Sarah Hopkins - 300 Fore Street

From: "Thomas Errico" <terrico@wilbursmith.com>
To: <SH@portlandmaine.gov>
Date: 02/23/2006 11:30 AM
Subject: 300 Fore Street
CC: <JBP@portlandmaine.gov>, "Katherine Earley" <KAS@portlandmaine.gov>, <WBN@portlandmaine.gov>

**Memorandum
Department of Planning and Development
Planning Division**

Re: Fore Street and Custom House Street Office Building
February 28, 2006 Planning Board Workshop

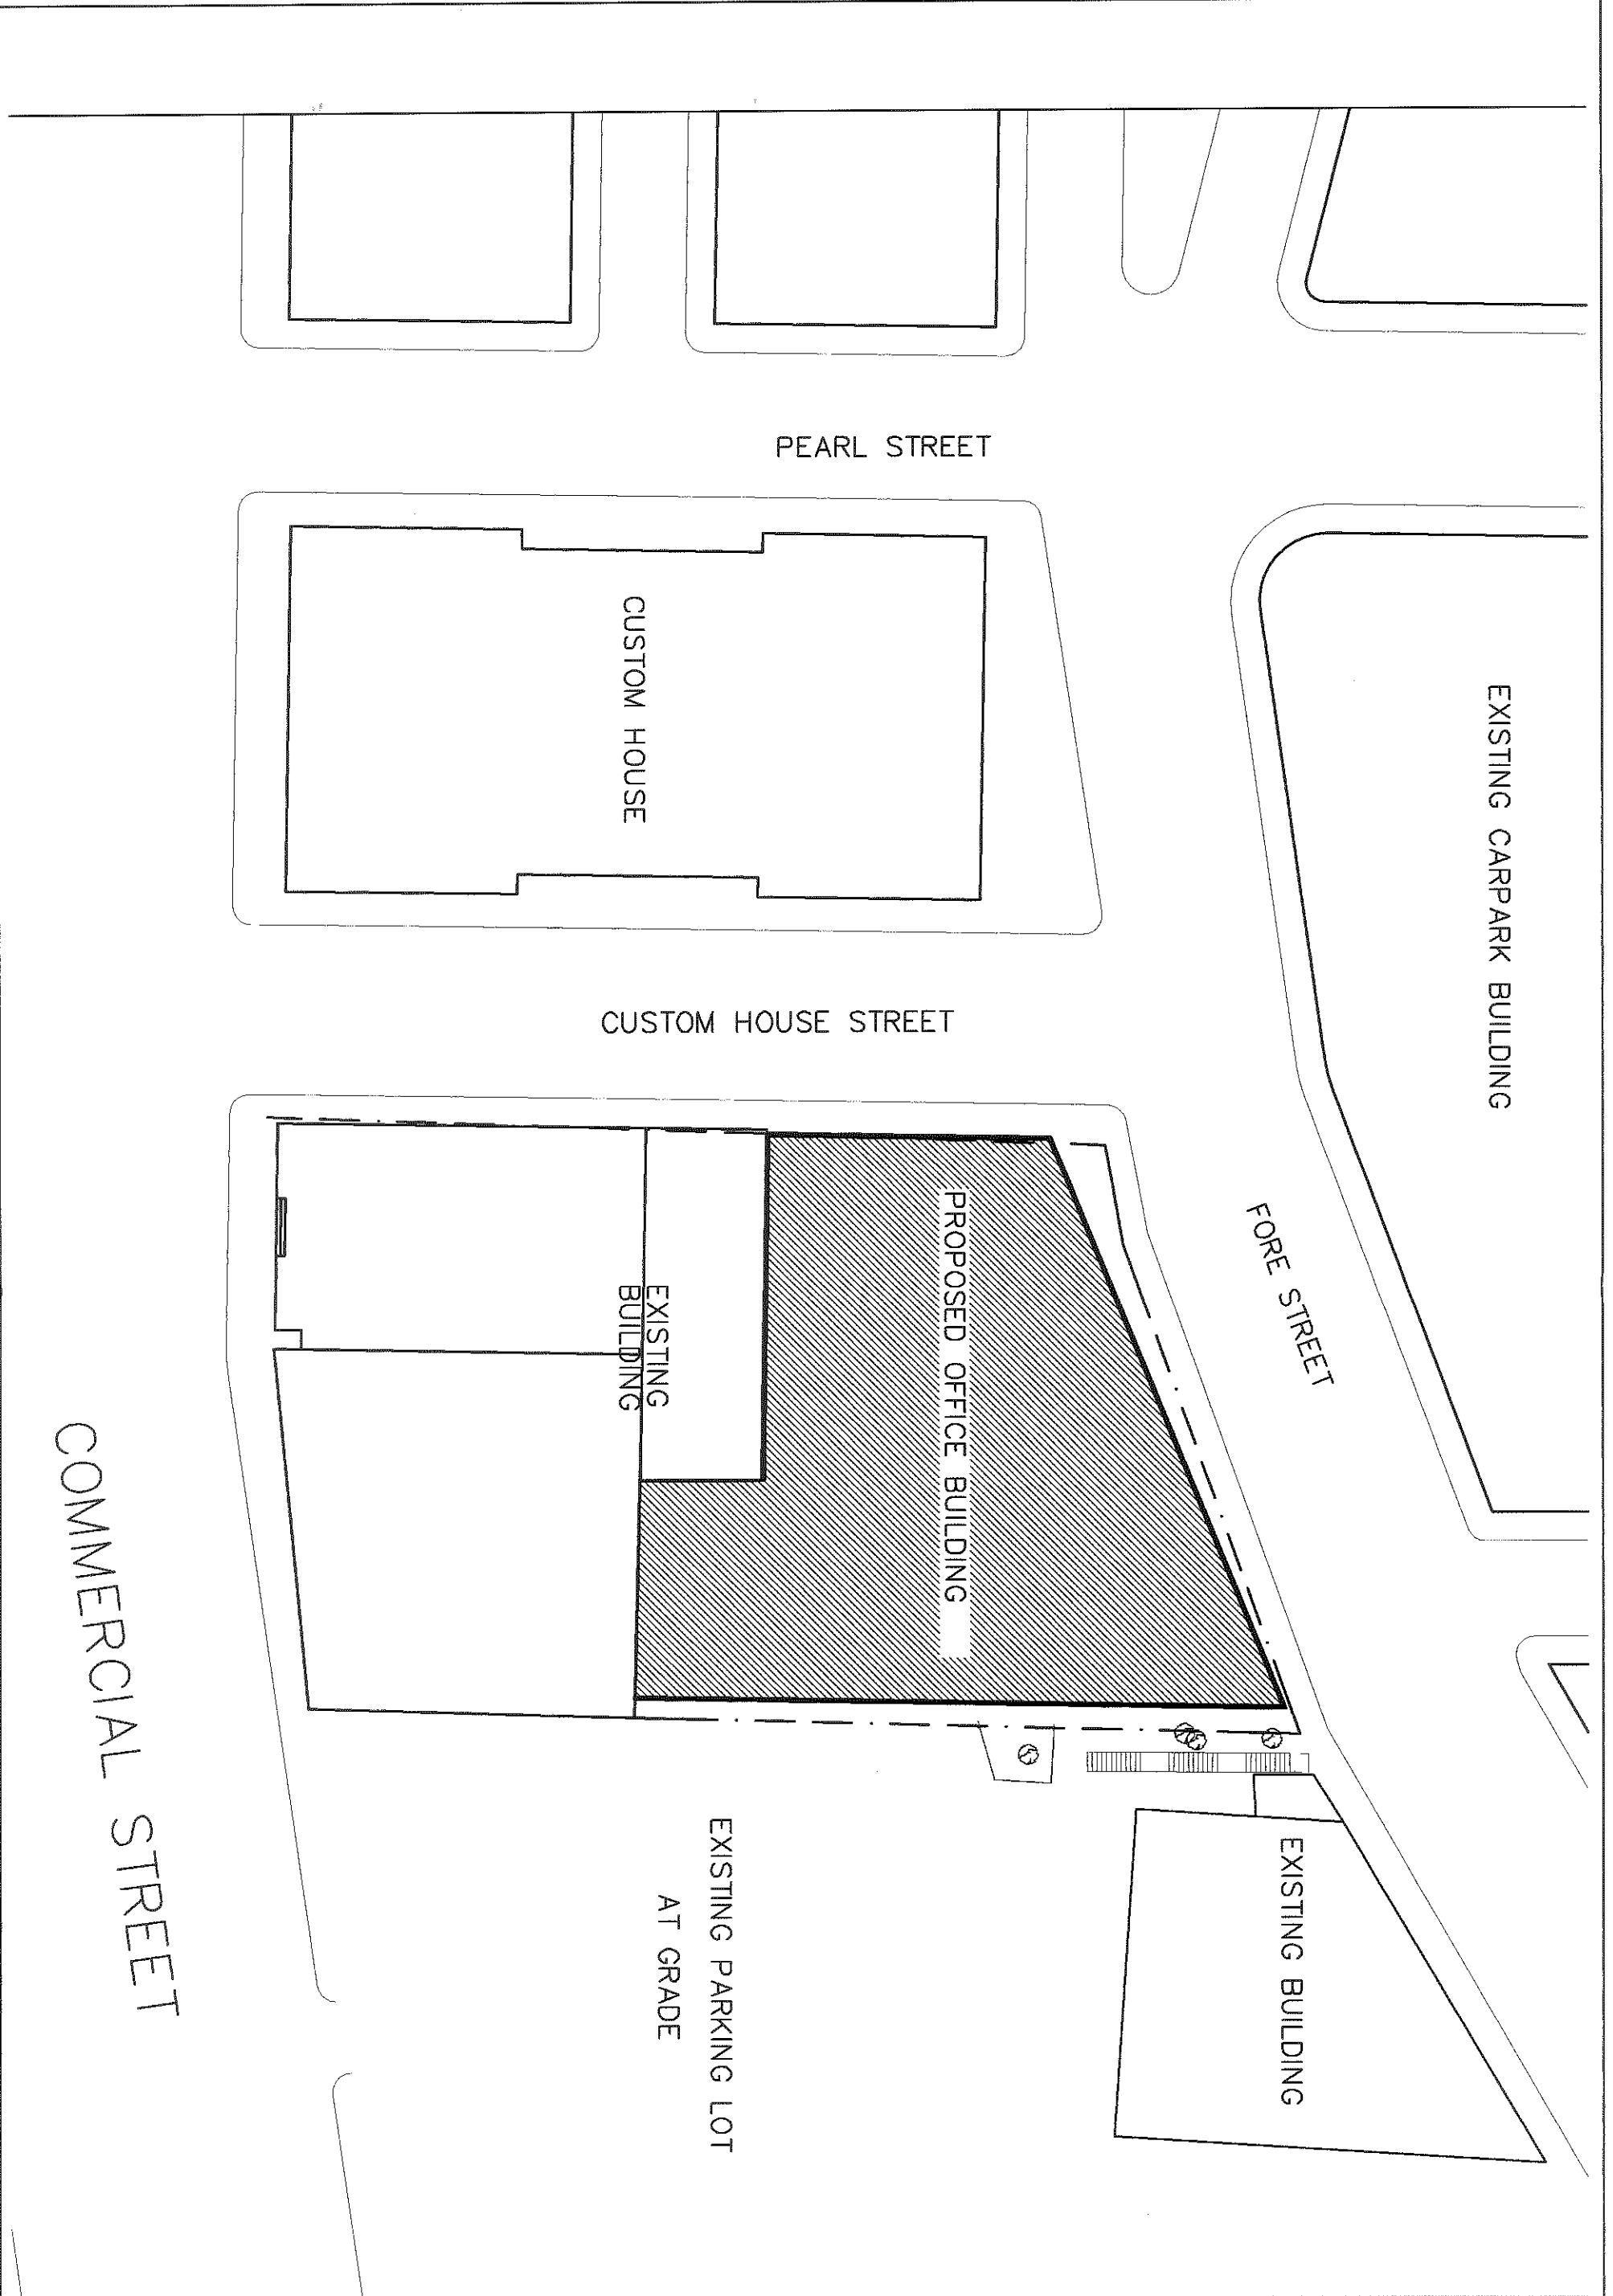
- The proposed plan indicates a garage door will be provided on Custom House Street, but vertical curbing will be provided. An explanation should be provided.
- I generally concur with the layout of Fore Street with two 12-foot travel lanes, an 8-foot parking lane on the south side and a varying shoulder width on the north side.
- The City generally does not provide edge pavement markings and accordingly it should be deleted from the plan.
- In the vicinity of Custom House Street, the eastbound travel lane is illustrated as being 24 feet wide. It seems that there may be an opportunity to adjust the curb line adjacent to the proposed building to better align with the curb in front of the Custom House building. This adjustment may result in additional sidewalk area at the corner.
